Response to Planning Application

Application ref: A/159/25/PL

Description: Demolition of existing pavilion; erection of new Sports and Community Hub comprising of new 3G football pitch, improved turf pitches for football, multi-use games area, locally equipped play area, hub building, storage facility, car parking, EV charging points, access road, landscaping, associated works and infrastructure (resubmission following A/222/24/PL). This application is in CIL Zone 3 (Zero Rated) as other development.

Location: Sports Pavilion Decoy Drive Angmering BN16 4DN

UBU Design LTD 7a Wintex House, Easton Lane Business Park, Easton Lane, Winchester, Hants, SO23 7RQ +44 (0) 1962 856 008 studio@ubu-design.co.uk www.ubu-design.co.uk
	PROJECT: ANGMERING SPORTS HUB TITLE: LANDSCAPE STRATEGY PLAN

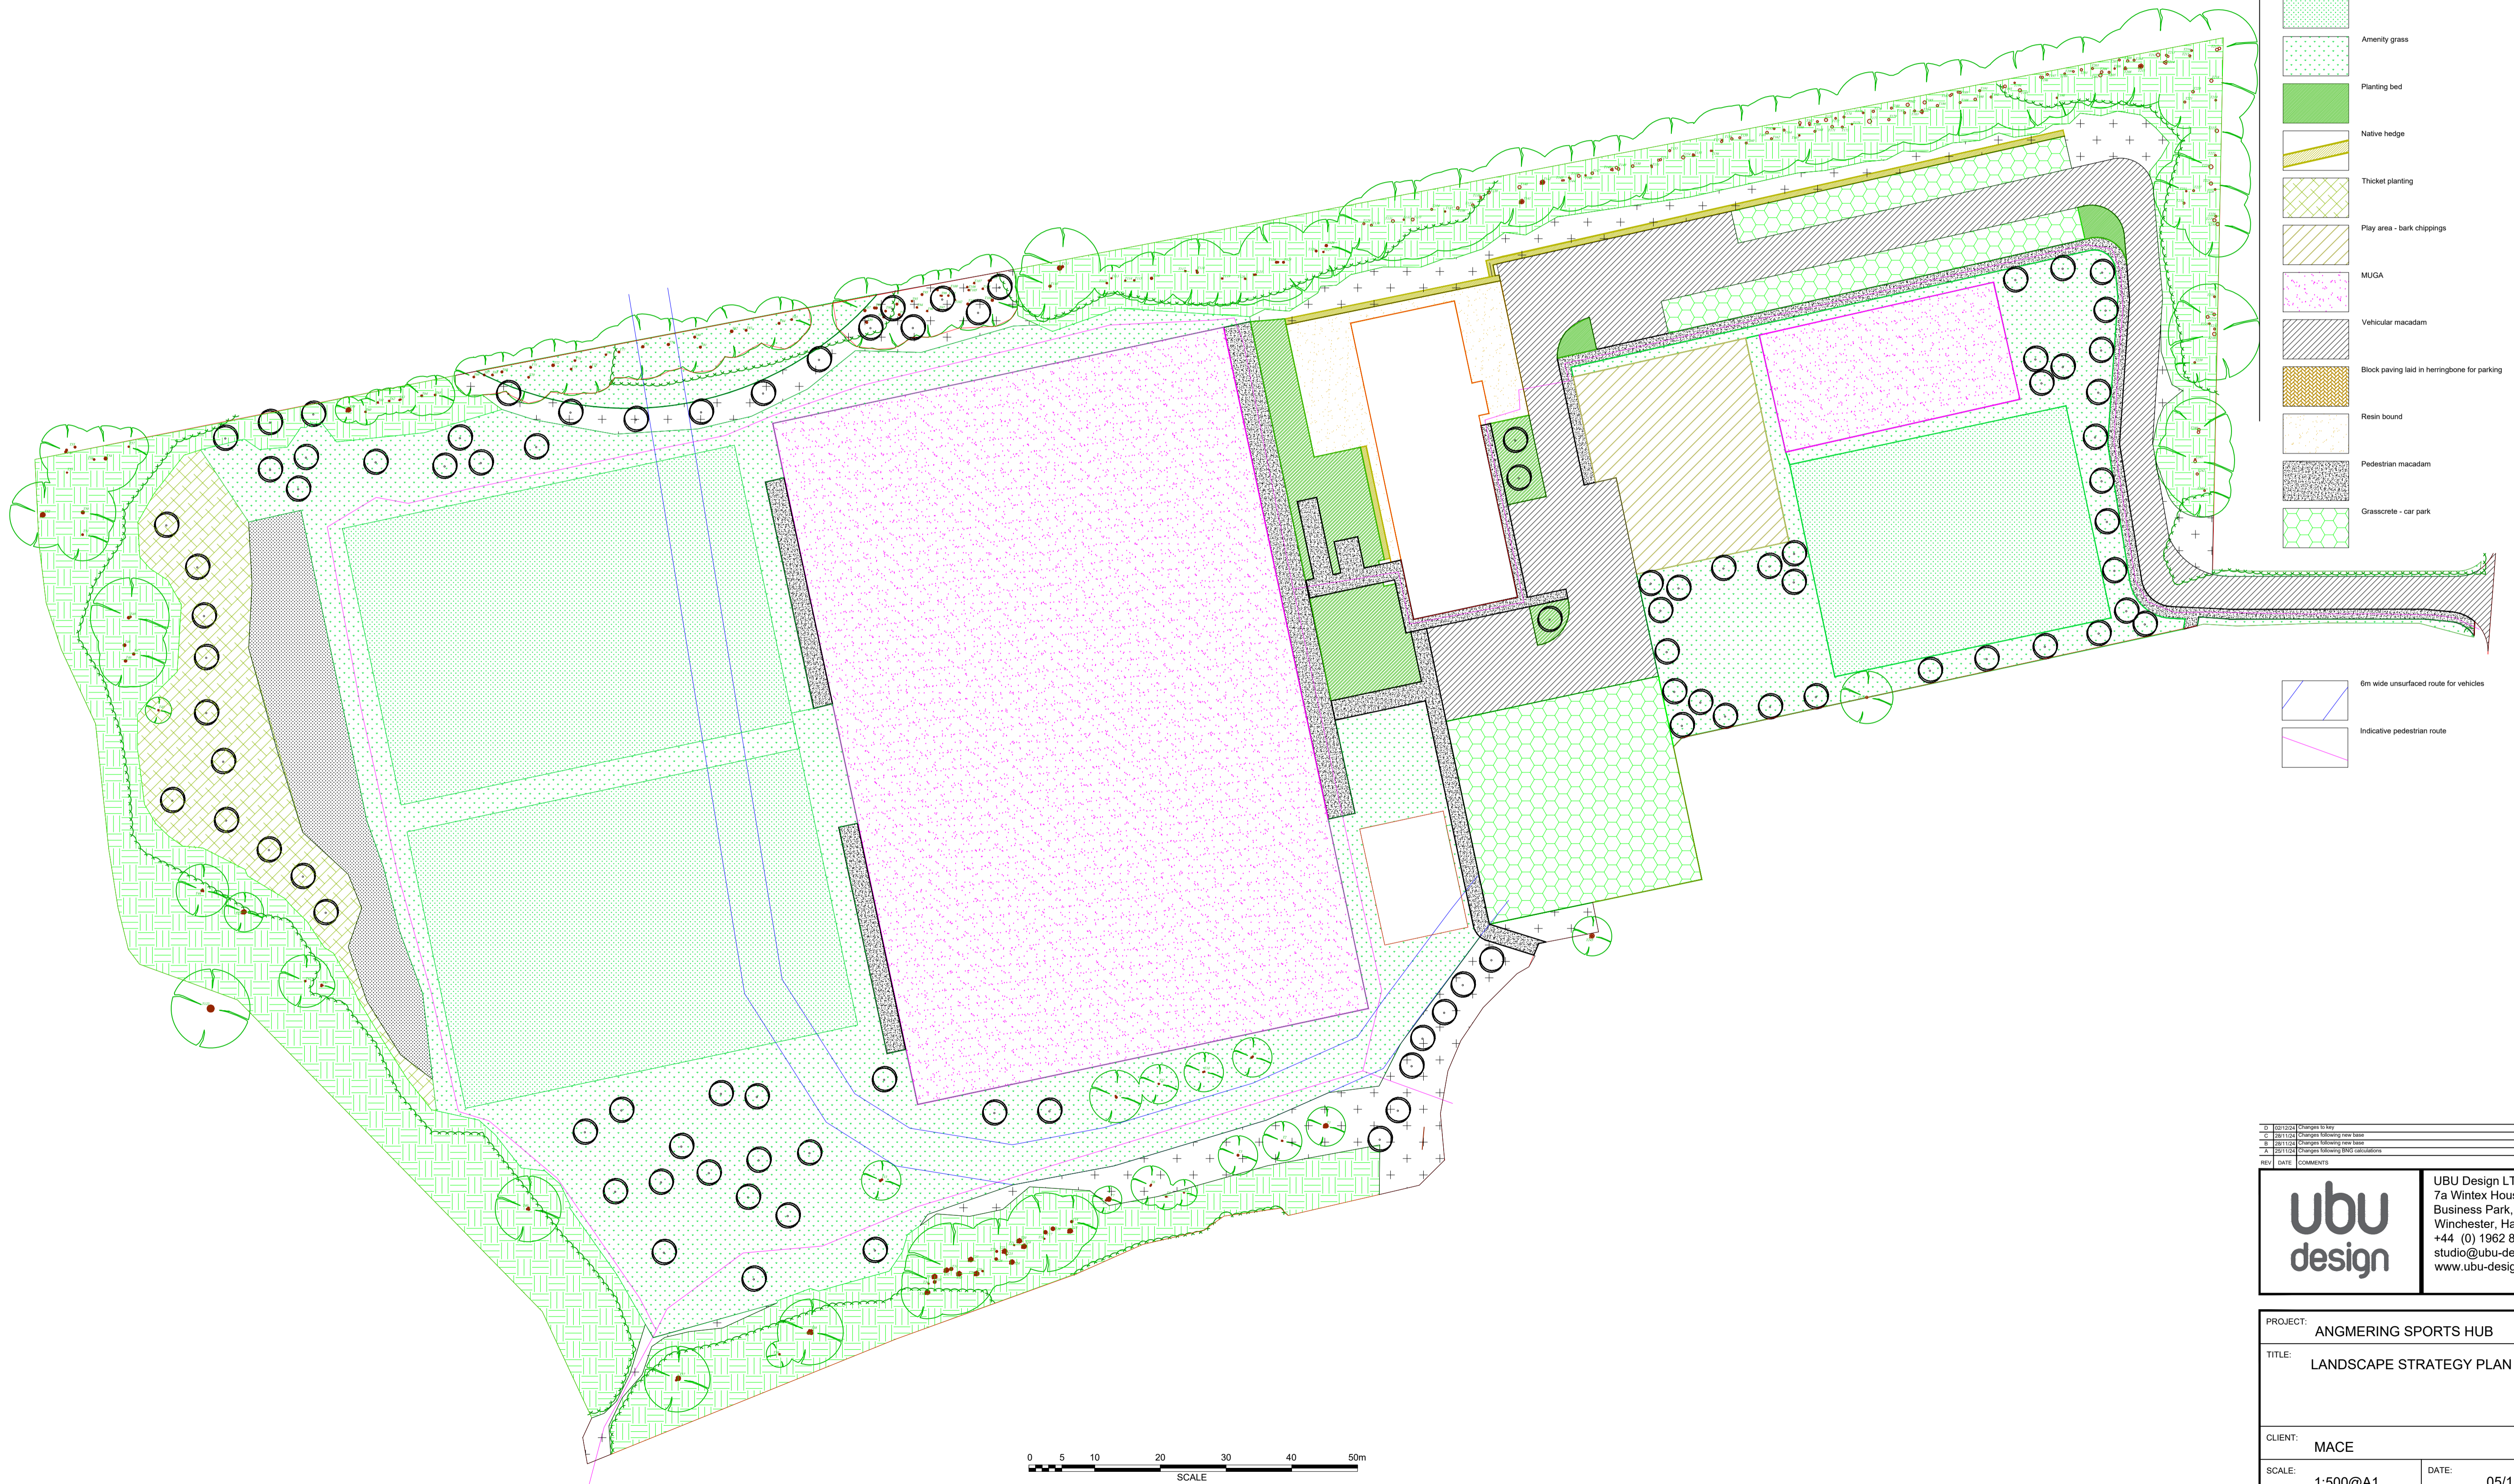
The soft landscaping as presently shown is largely indicative and detailed further within Landscape Strategy Plan 5

Existing and to be retained green infrastructure has been shown along with proposed tree removals; which will be required to accommodate the southern end of the cricket pitch proposals. Detailed soft landscaping plans in line with screening and Biodiversity Net Gain (BNG) requirements will need to be submitted for approval proposing a comprehensive scheme to include native and ornamental species with a good range of species composition allowing for diversity across the site. Tree proposals will need to be selected for suitability to location and supplied at a size which will allow instant impact and form a well-structured scheme. Soft landscape detail will need to be submitted in scaled plan form detailing species choice, quantities, planting densities and size at time of planting. A maintenance and management programme will also need to be submitted to ensure adequate provision to support establishment and ensure the scheme will thrive to maturity. Buffer zone planting areas need to be of suitable depth and species composition.

A full and detailed landscape scheme will be required to be submitted for approval, detailing quantities, species choice, position, densities and size at time of planting. This should be plotted in plan and list form and in relation to the trees and vegetation to be retained so that a clear picture of the proposals can be seen.
